RE: Harnett County Land Use Application 05-5-12437

An Environmental Health Specialist from the Harnett County Health Department attempted to evaluate your property for the purpose of issuing an Improvement Permit. This individual was unable to evaluate your property for one or more of the following reasons.

SITE PLAN APPROVAL
 DISTRICT RA2em USE Dum
 #BEDROOMS 3
6-21-05
 ZONING ADMINISTRATOR

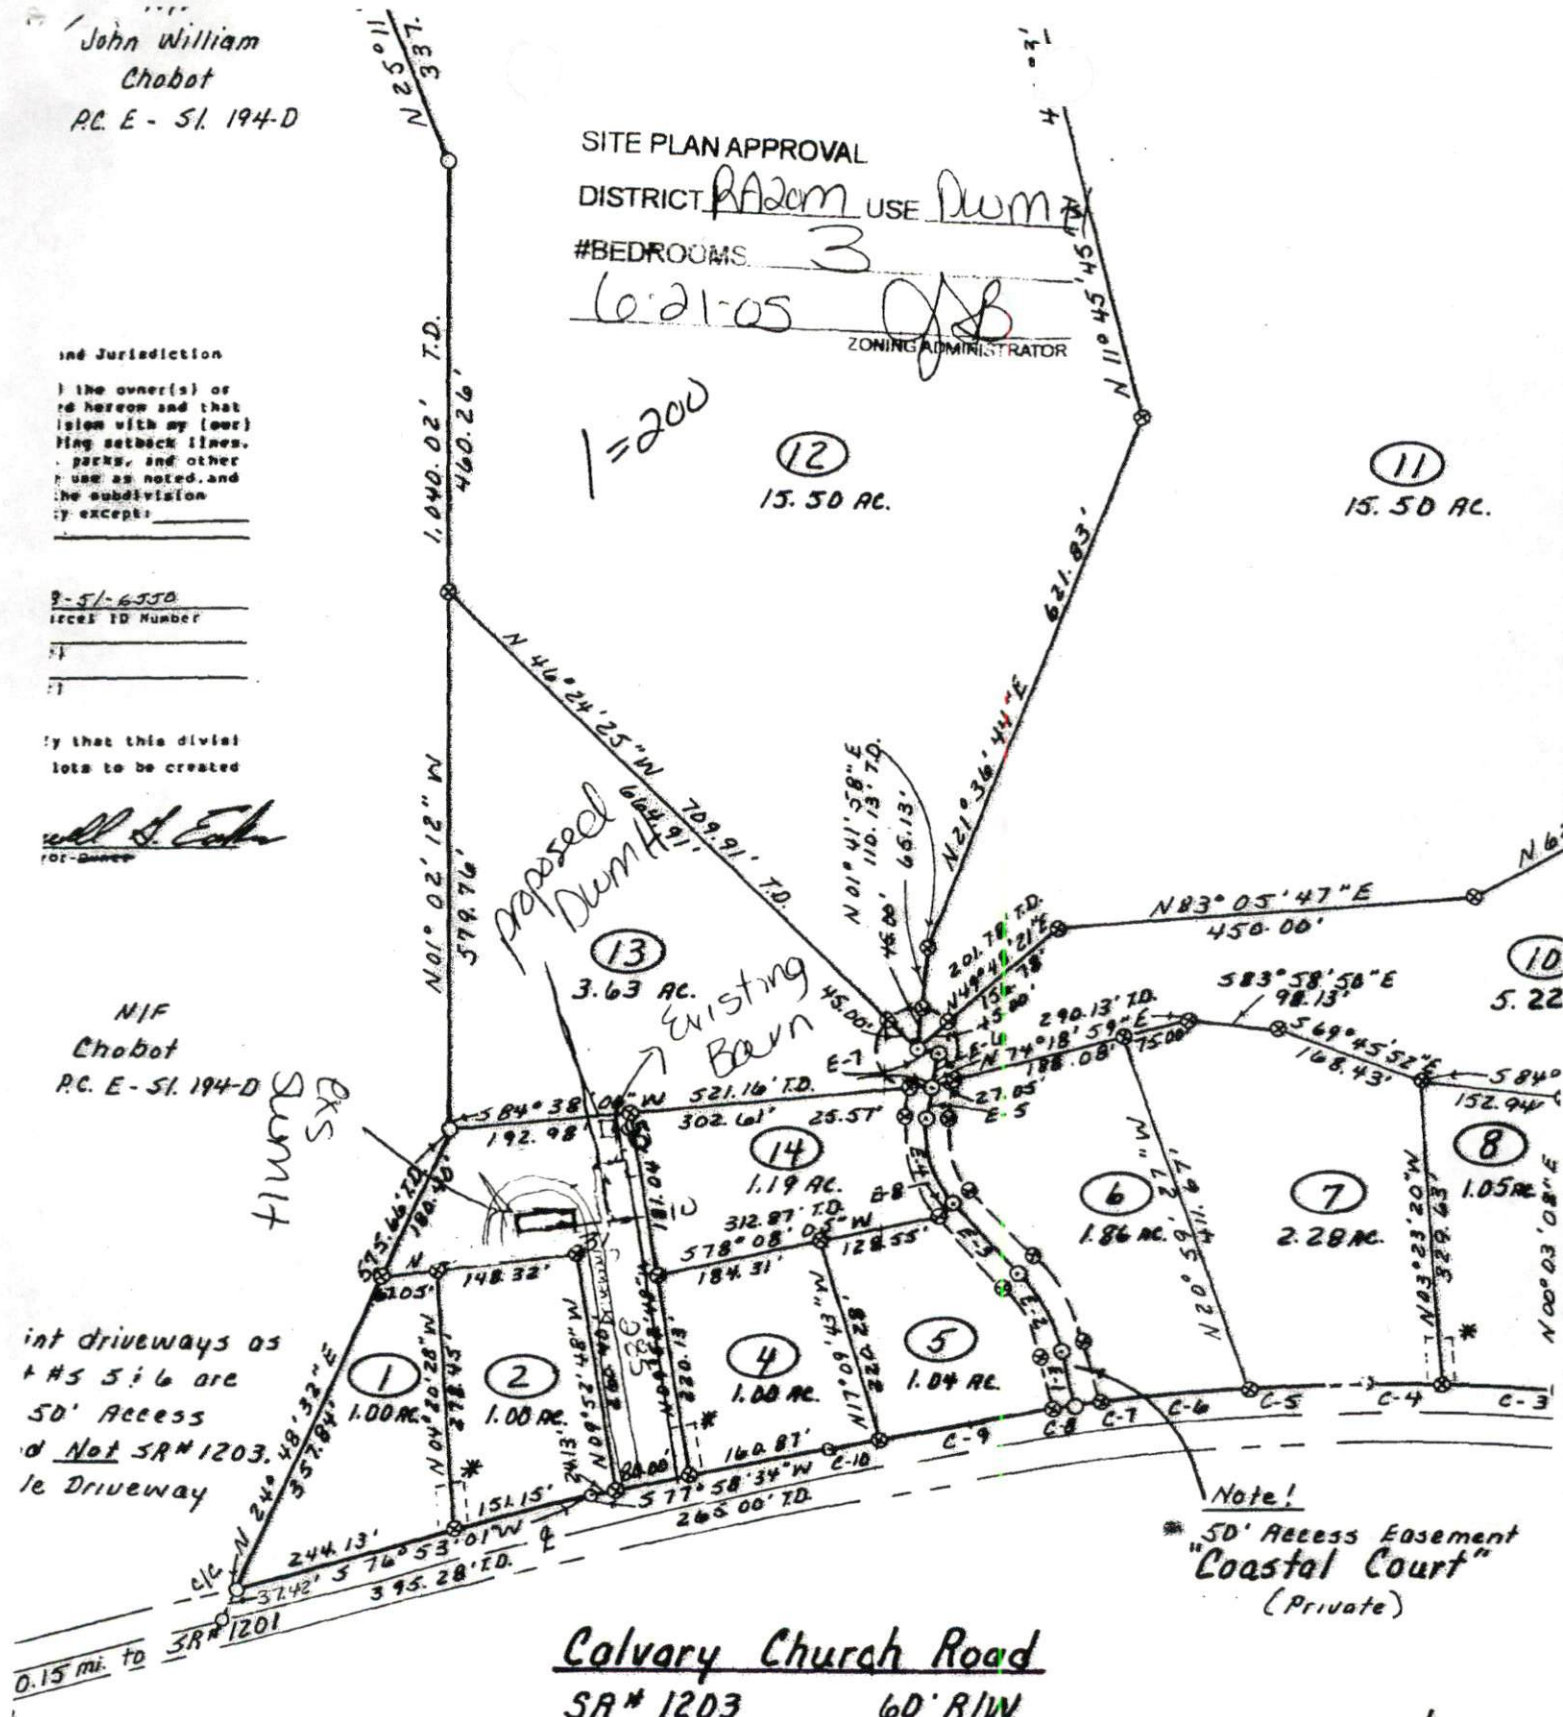
- 1. Property lines/corners not marked or labeled
- 2. House corners not marked or labeled
- 3. Directions not clear to property
- 4. Property needs brush or vegetation remove
- 5. Backhoe pits required
- 6. Other *Your house site is on top of designated area for repair for existing home. Please uncover septic tank and Distribution Box for existing home so that I may be able to locate drain lines to see how much repair area I need for existing home and where the new home may be placed, out of the repair area.*

When you have completed # 1 & #6 please call 910-893-7547 to confirm that the items mentioned have been corrected, we will then reschedule your property for evaluation.
